**REQUEST**

Current Zoning: N1-A (neighborhood 1-A)  
Proposed Zoning: R-8MF(CD) (multi-family residential, conditional)

Approximately 24.96 acres located on the south side of Allen Road East and east side of Citadel Place, west of Allen Road South.

The petition proposes a residential community of up to 84 single-family attached townhouse style dwelling units.

TITLE  
PRELIMINARY SITE PLAN  
R-8 (CD)  
RZP\_2023\_011

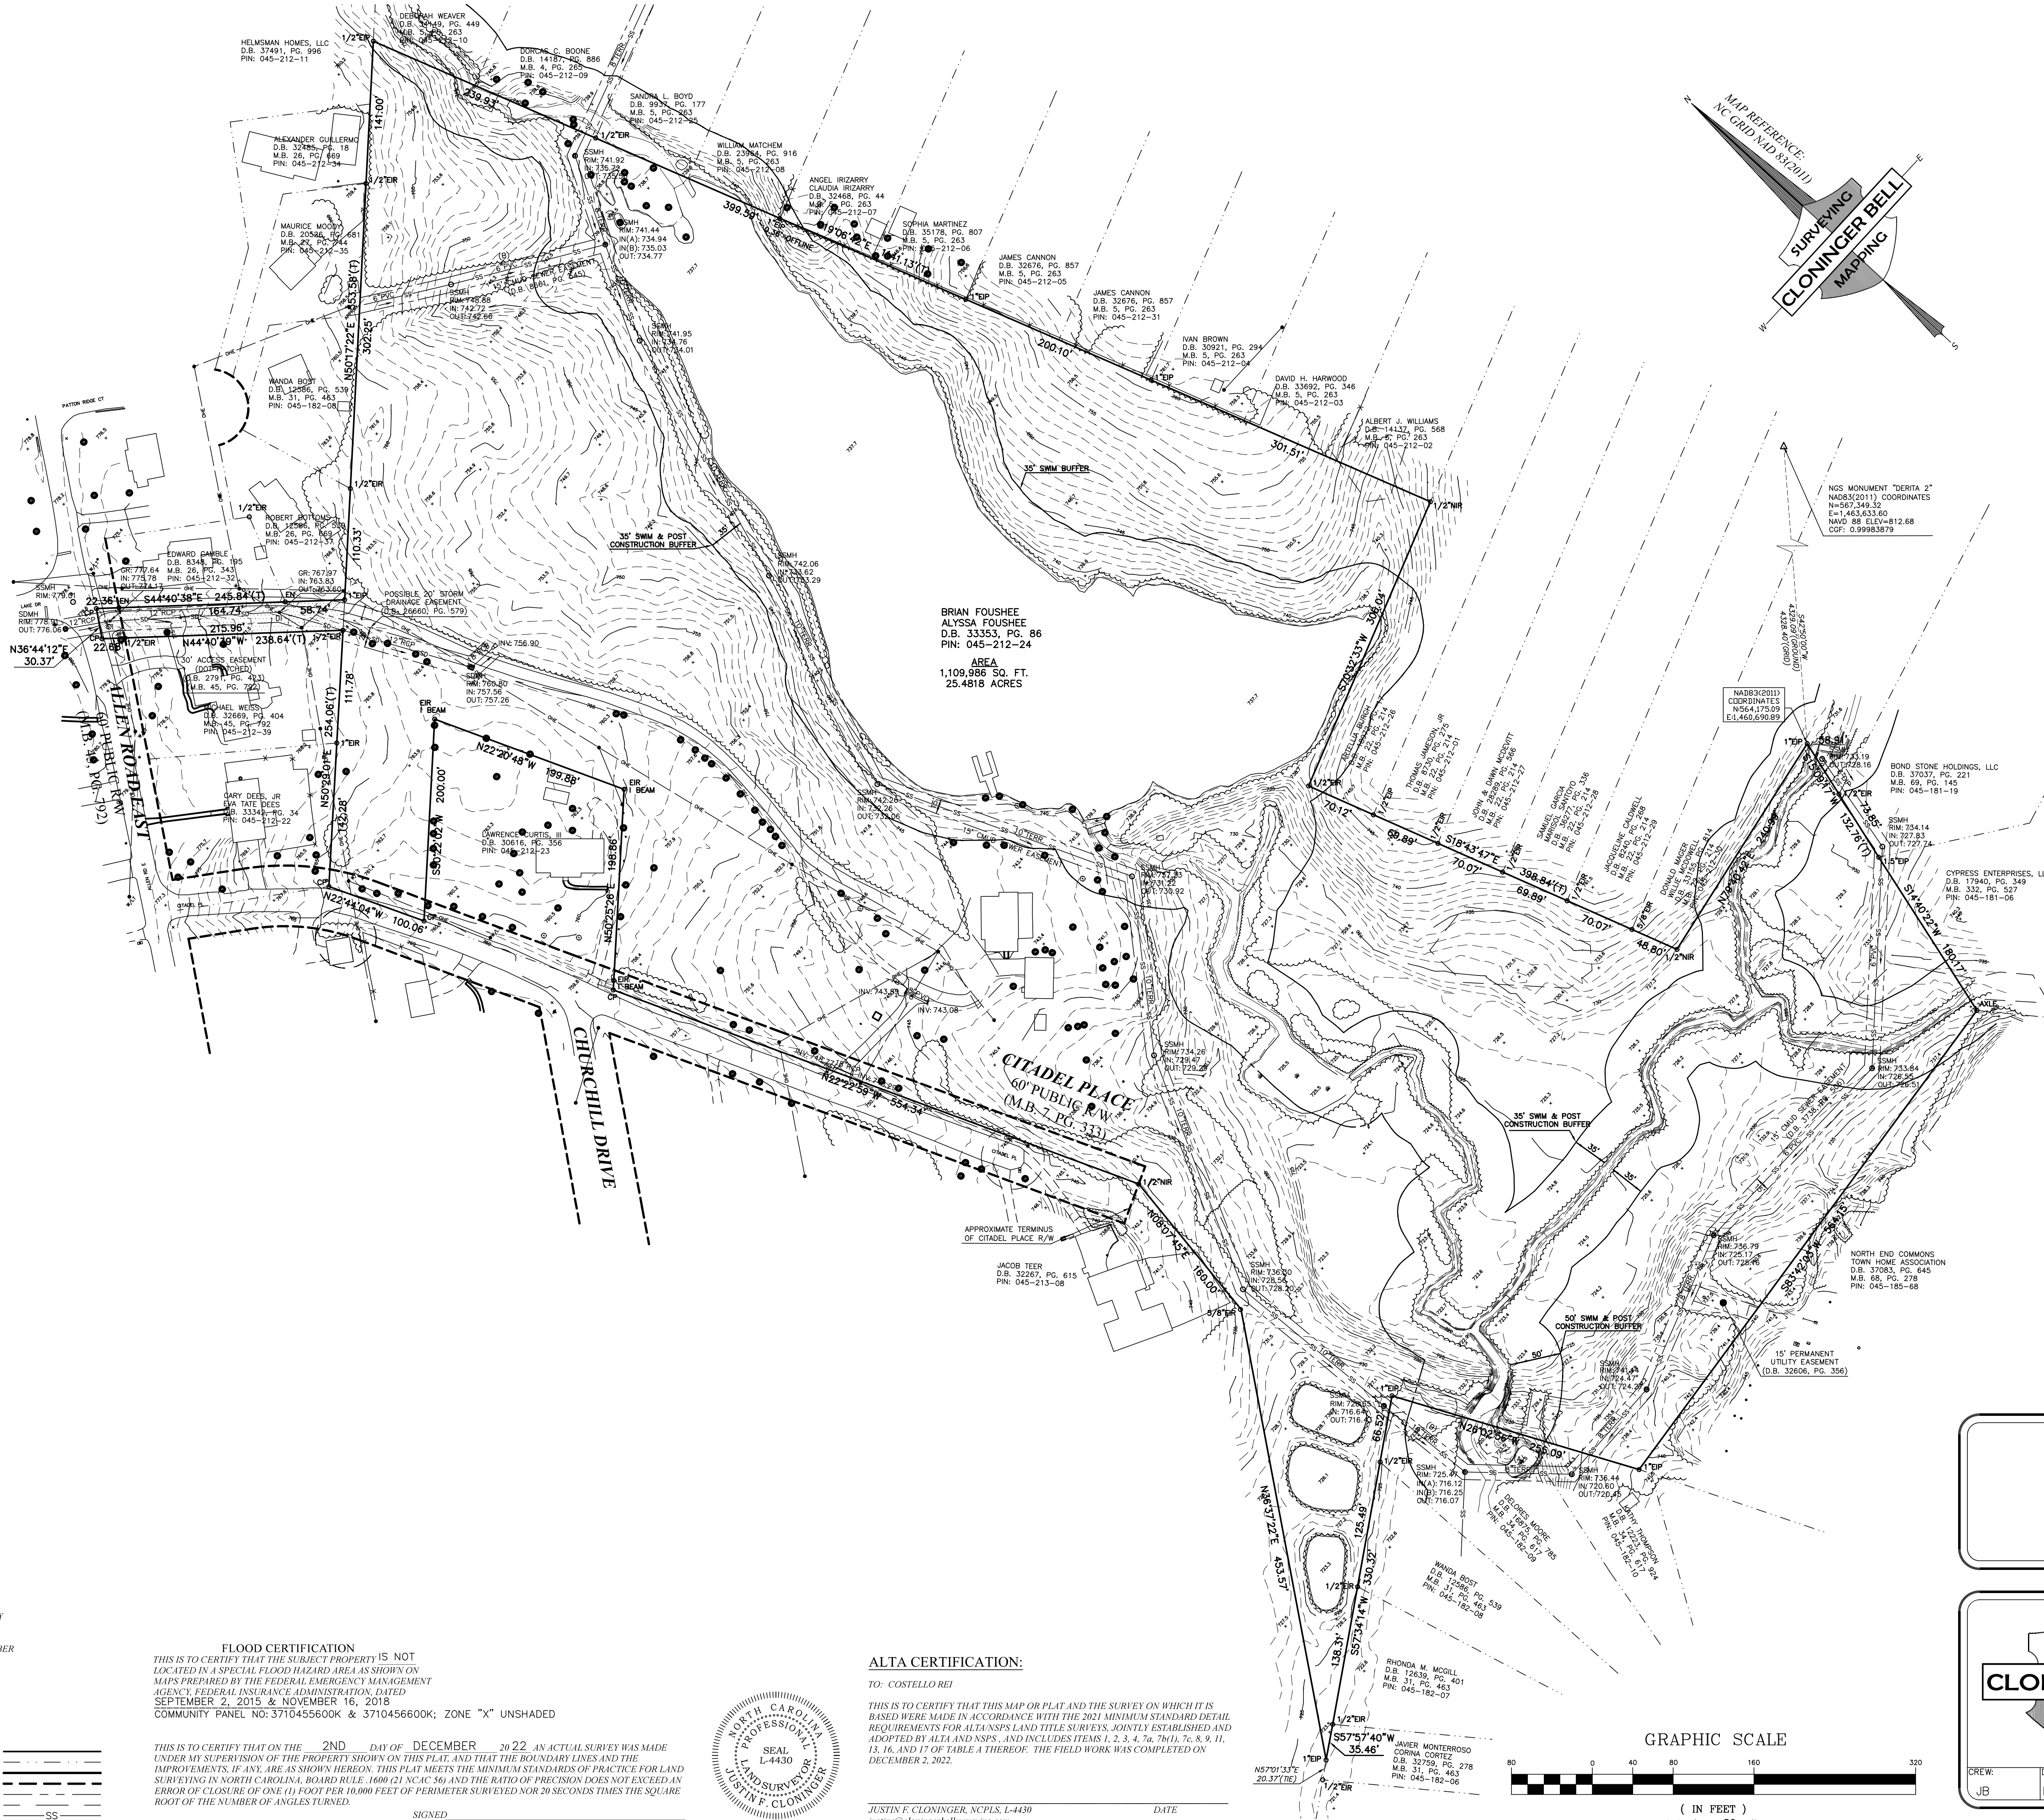
1. Reduce unit count and incorporate a mix of buildings that better align with the N1 Place Type (duplexes, triplexes)
2. Relocate proposed dumpster location away from existing houses.
3. Add visitor parking areas.

4. Revise the park note to read: "land to be dedicated and conveyed to Mecklenburg County."
